SUBJECT: Papa Felipe's Restaurant
9800 Menaul, N.E.
Albuquerque, New Mexico

H-21-D11

RE: PAPA FELIPE'S RESTAURANT DRAINAGE PLAN

Subject: Drainage Plan for Papa Felipe's Restaurant
9800 Menaul Blvd., NE
Zone Map H-21 - 011

GRADING PLAN

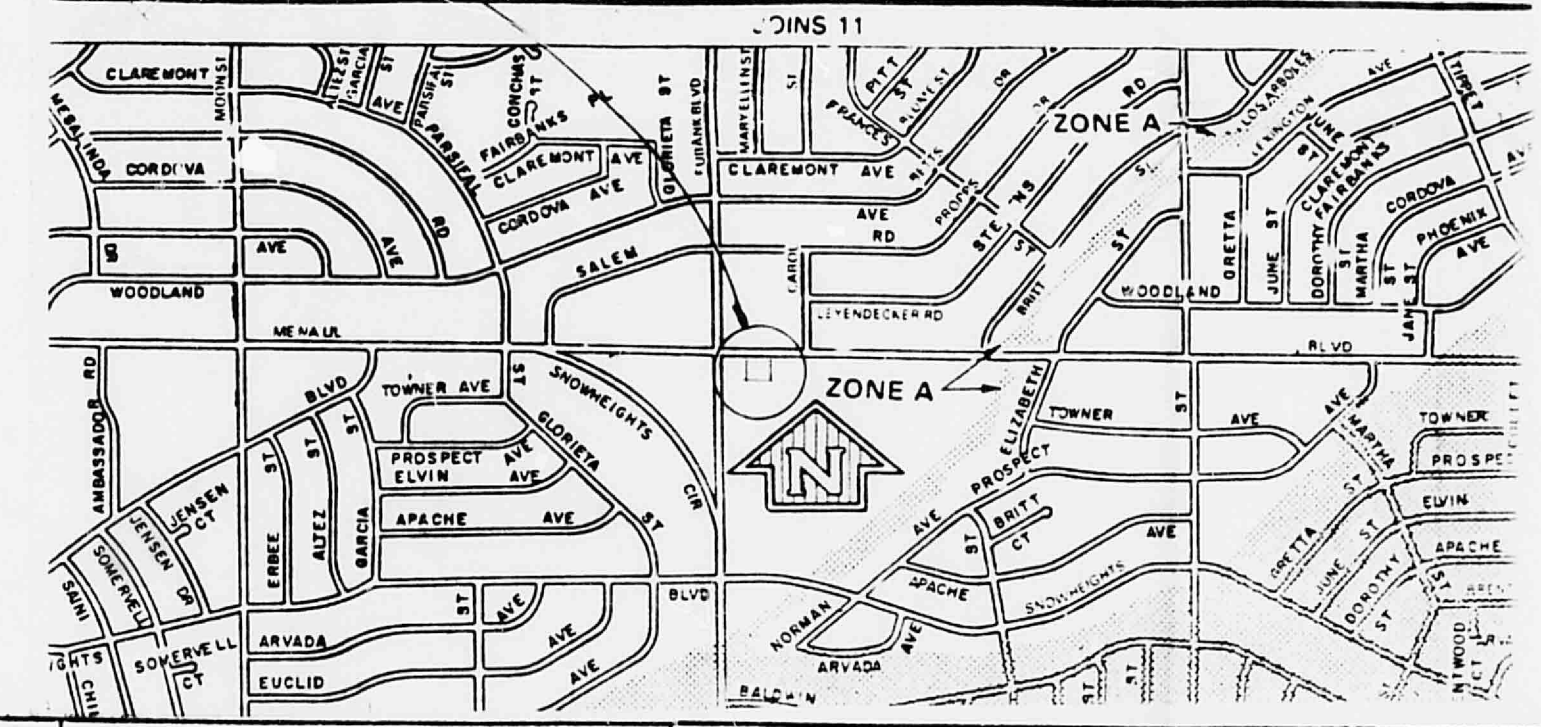
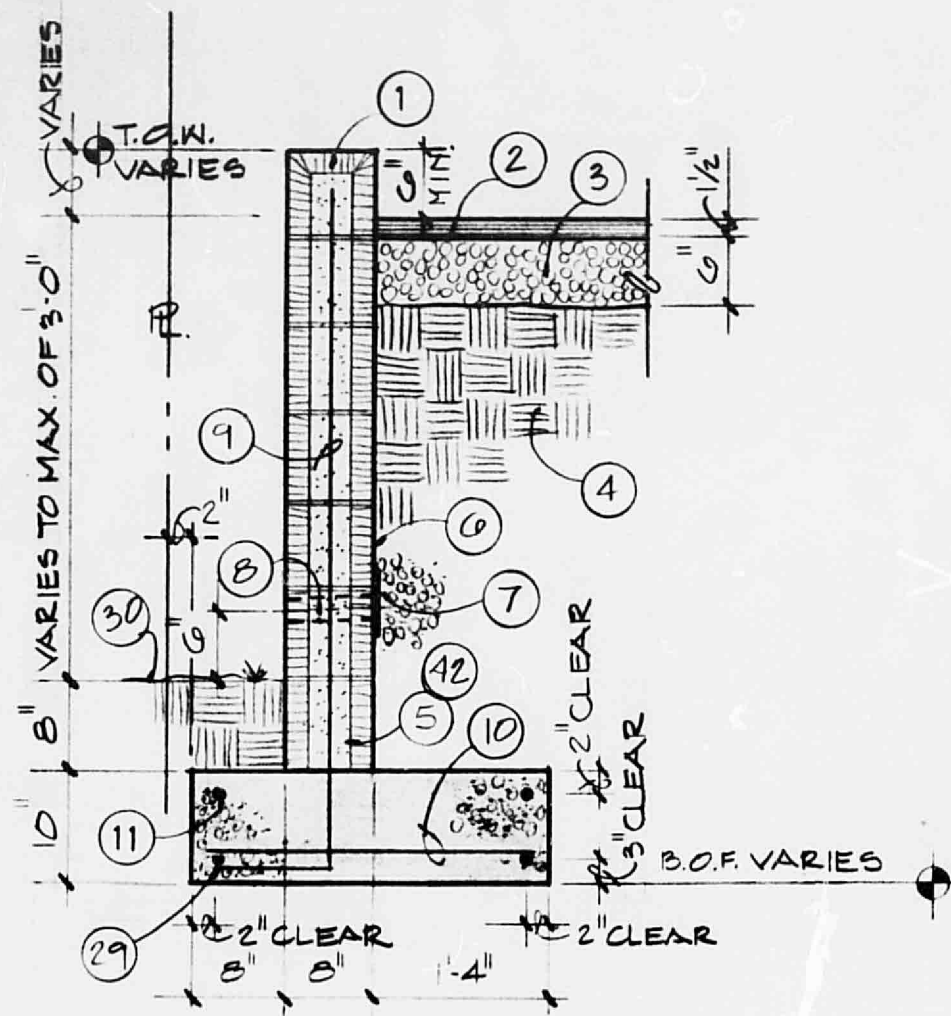
Inspection Requested 3/23/83 Contractor _____
Appr. _____ Disappr. _____ 30 Day Temp. 3/24/83
Comments: Need certification of ponding area by
the Engineer.
pond area certified by the Engineer
on 4/7/83

- a. ~~An~~ ^{OK BGB} ~~ecy-spillway~~ ^{8/20/82} should be provided for the Area B pond.
- b. An approved copy of Special Order No. 19 must be attached to the City construction sets before Hydrology signs-off.
- c. I appreciate you contacting the adjacent property owners in regards to the plan. Hopefully, this will help mitigate any further problems.

Attached are two copies of the drainage plan for the subject project. Per our telecon of 8/23/82, the site has been regraded at the owner's request, to collect most of the run-off at the southwest corner of the site. The detention pond has been increased in size to accommodate the increase in run-off. An emergency spillway has also been provided in the detention pond retaining wall in lieu of the overflow pipe leading back to Menaul. (This should eliminate the need for the Special Order 19 requested in your 8/19/82 letter.) Please expedite your review and approval, as hydrology is the only item outstanding prior to the issuance of a building permit. Call me if there are any questions.
